CITY OF ALBUQUERQUE

January 9, 2018

RE: **Homewood Suites - 5400 San Antonio Dr. NE**
Grading and Drainage Plan
Engineer's Stamp Date 12/26/2017
Hydrology File: E18D050

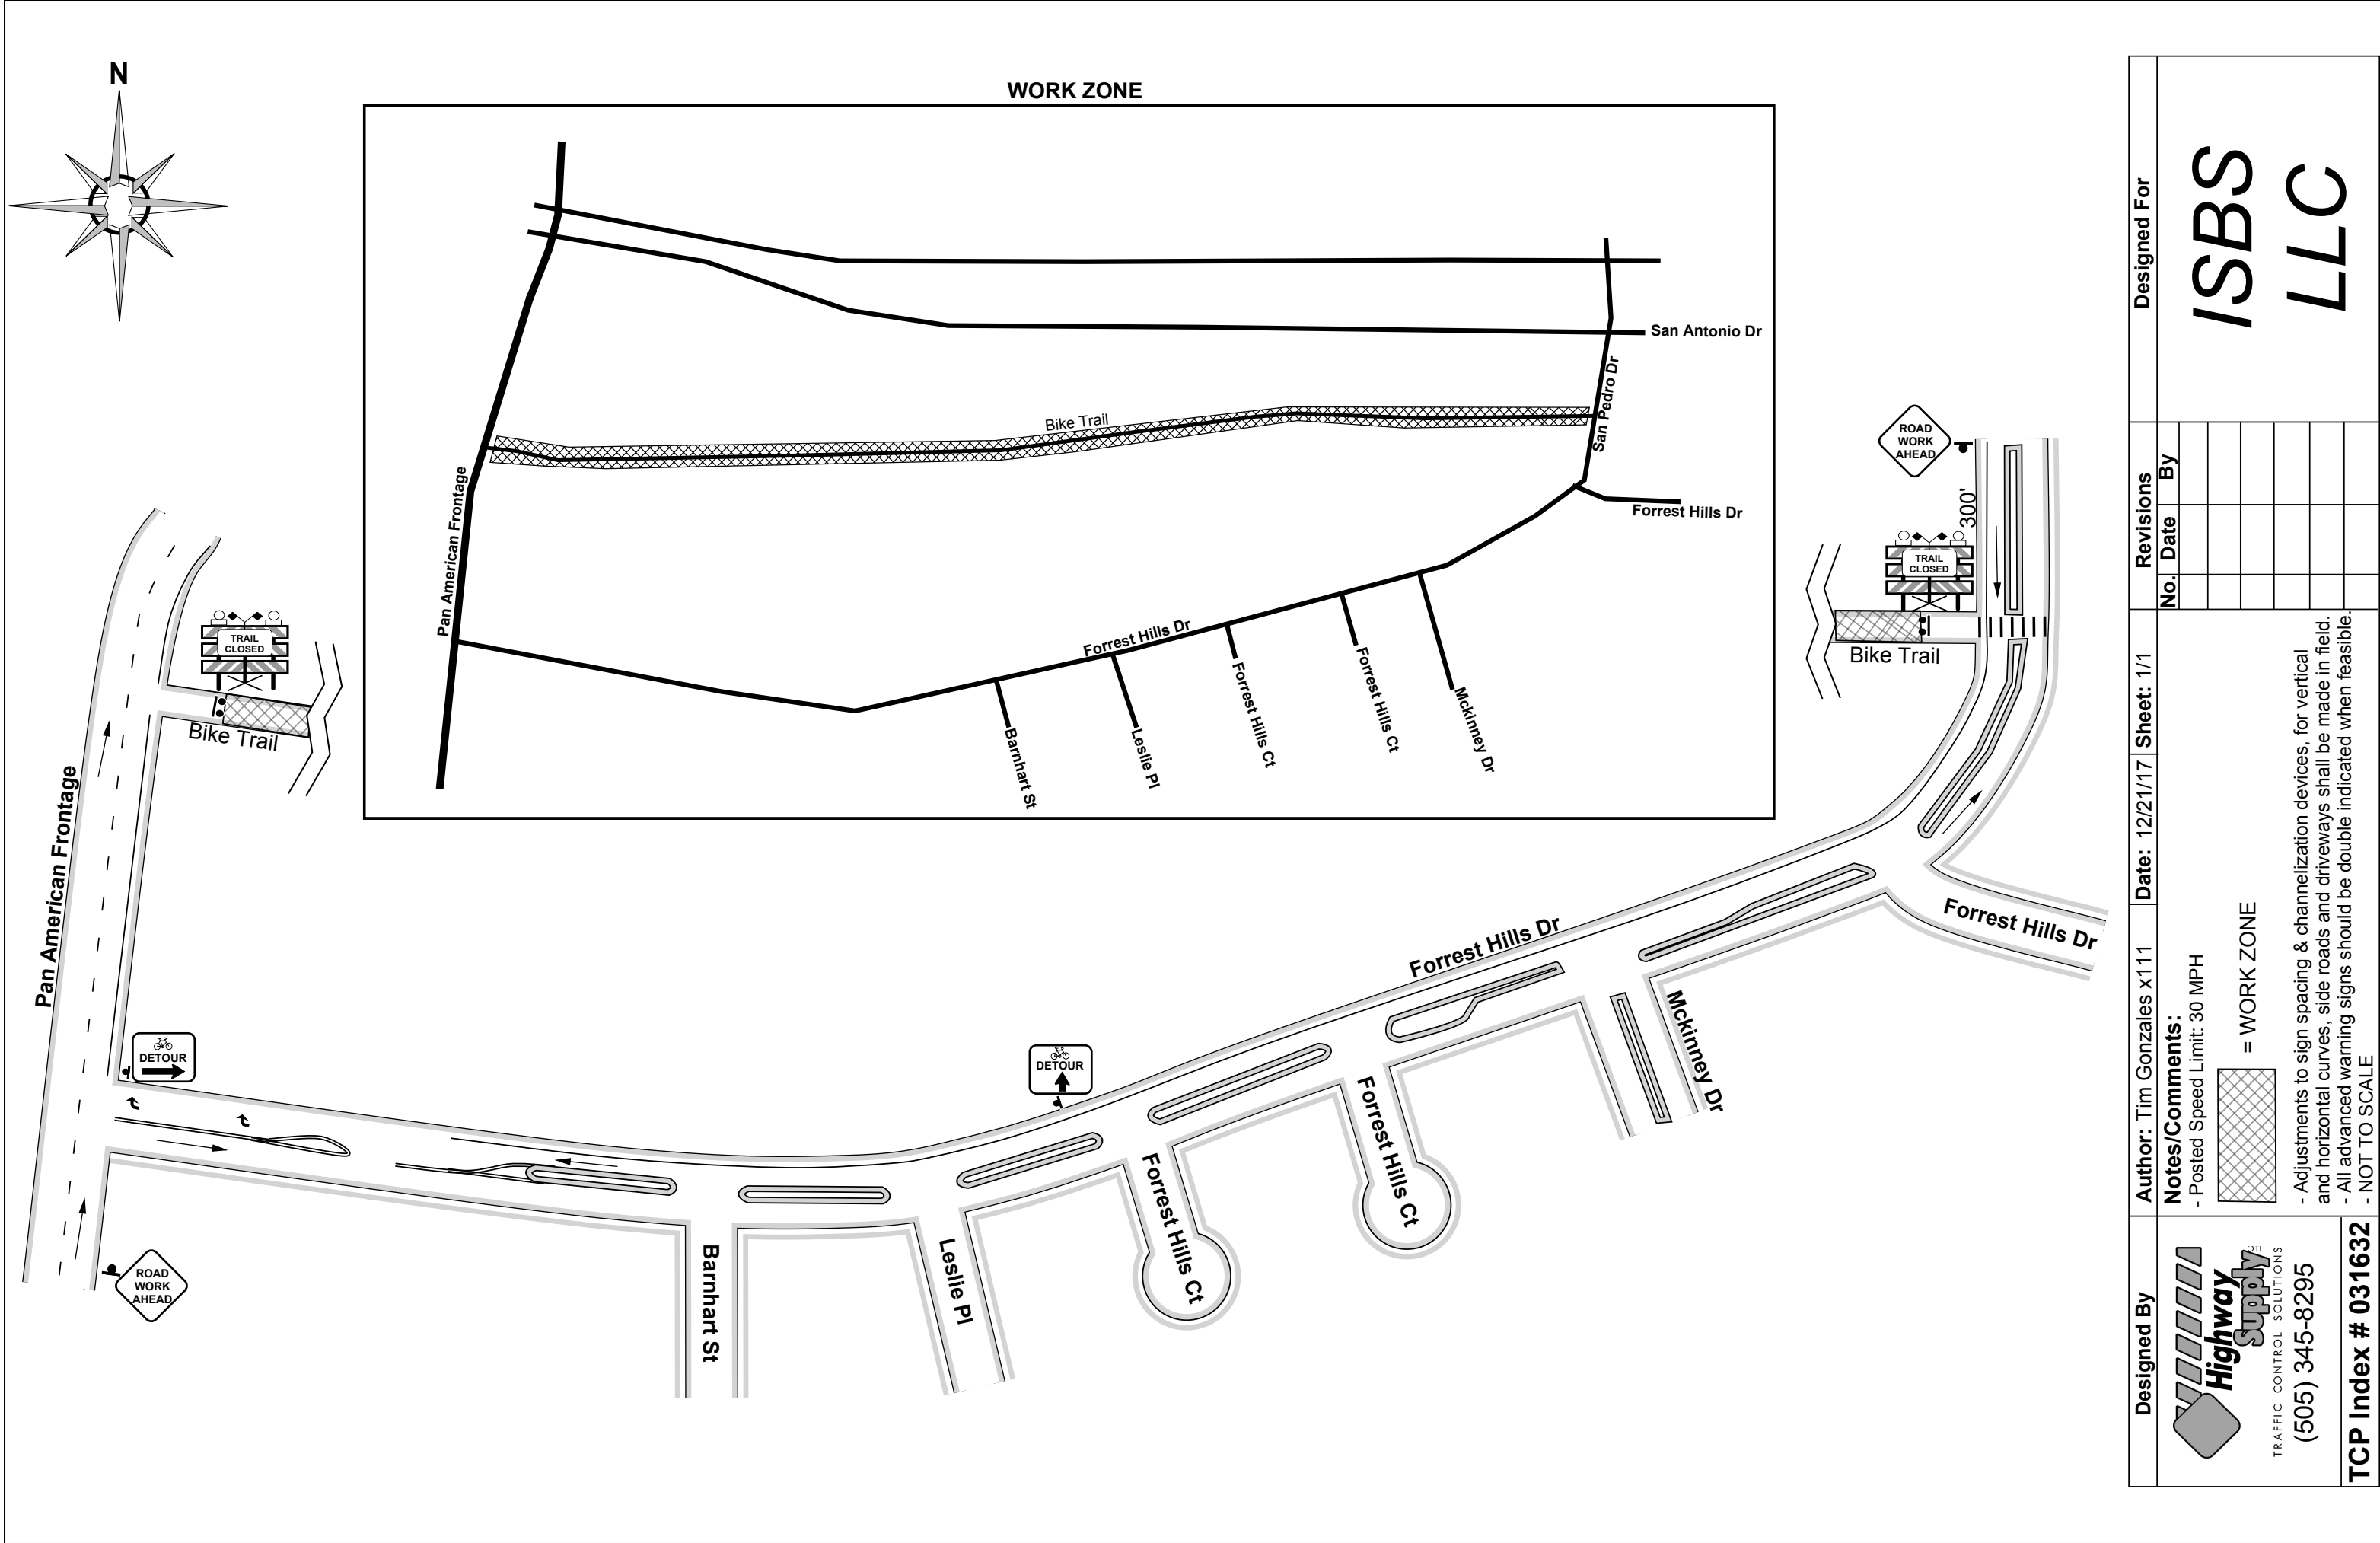
3. A temporary bridge across the San Antonio Arroyo is to be added to the DRC work order plan set that will include removal and replacement of a portion of the adjacent bike trail. The trail removal and replacement should be shown on the G&D Plan

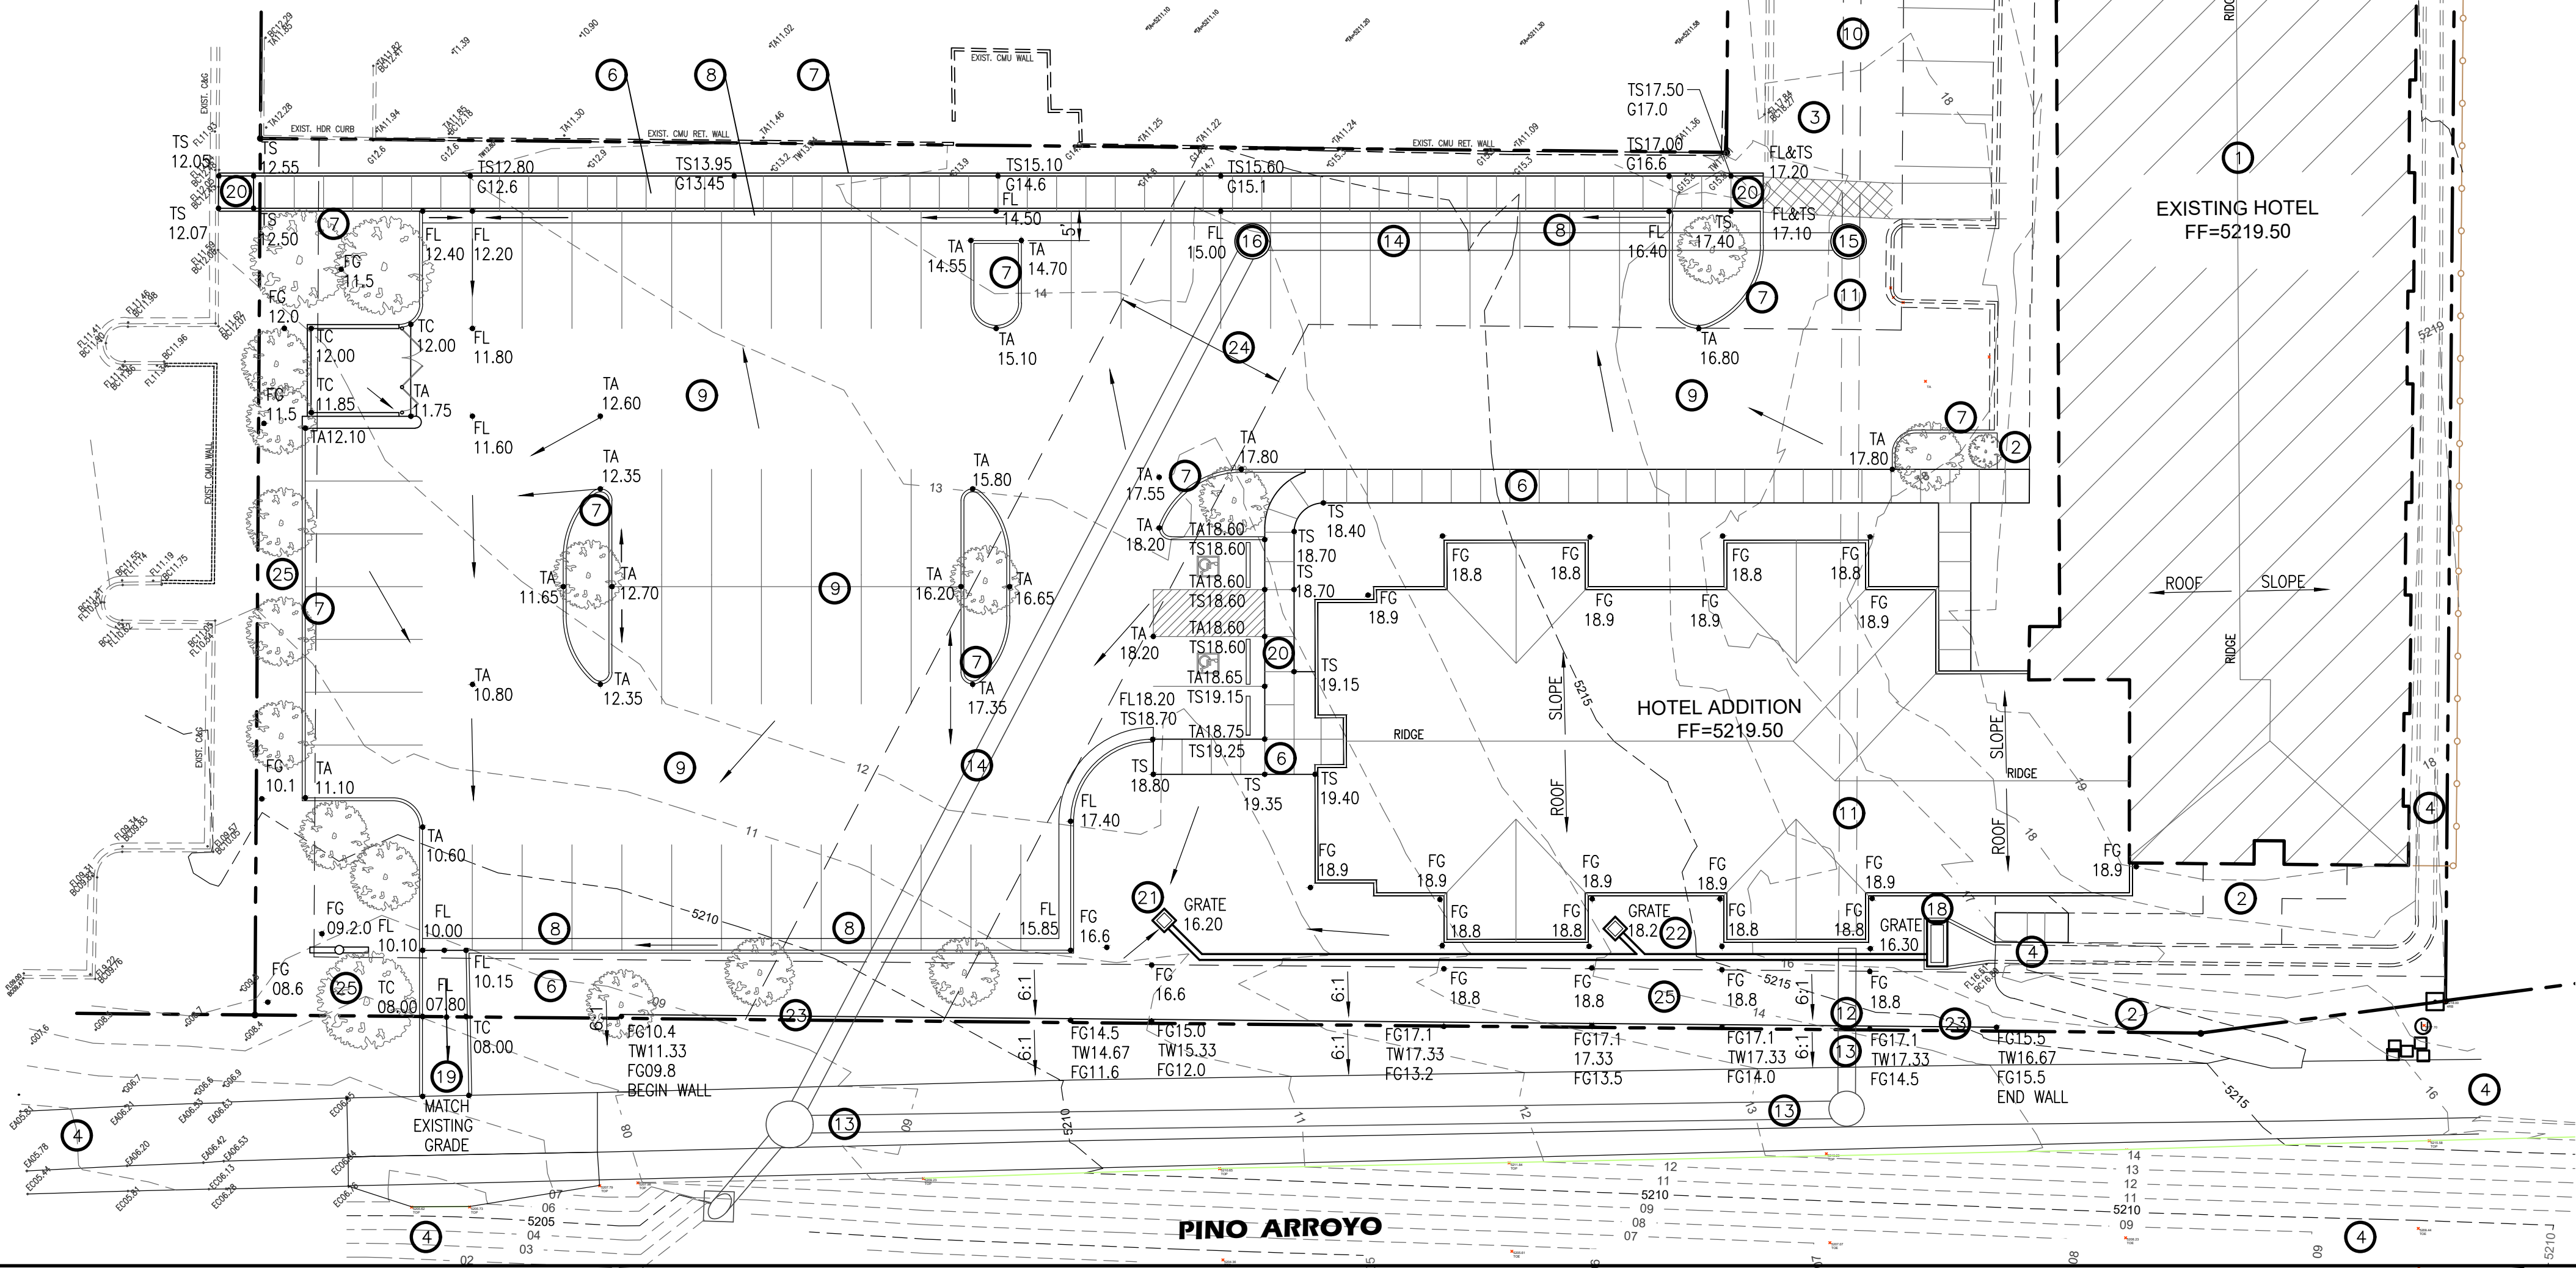
5. Written approval from Parks Department will be required for the trail closure prior to DRC approval.
6. The existing Public Storm Drain thru this site must remain functional at all times. Notes are to be added to the G&D Plan and the DRC P&P stating that temporary diversion ditches will be constructed and maintained when the storm drain is not in service.

12. Keynote # 4 should say private instead of public, unless you can provide records showing that the channel east of the building is public, and Keynote # 17 needs to be changed to reflect the relocated pipe.
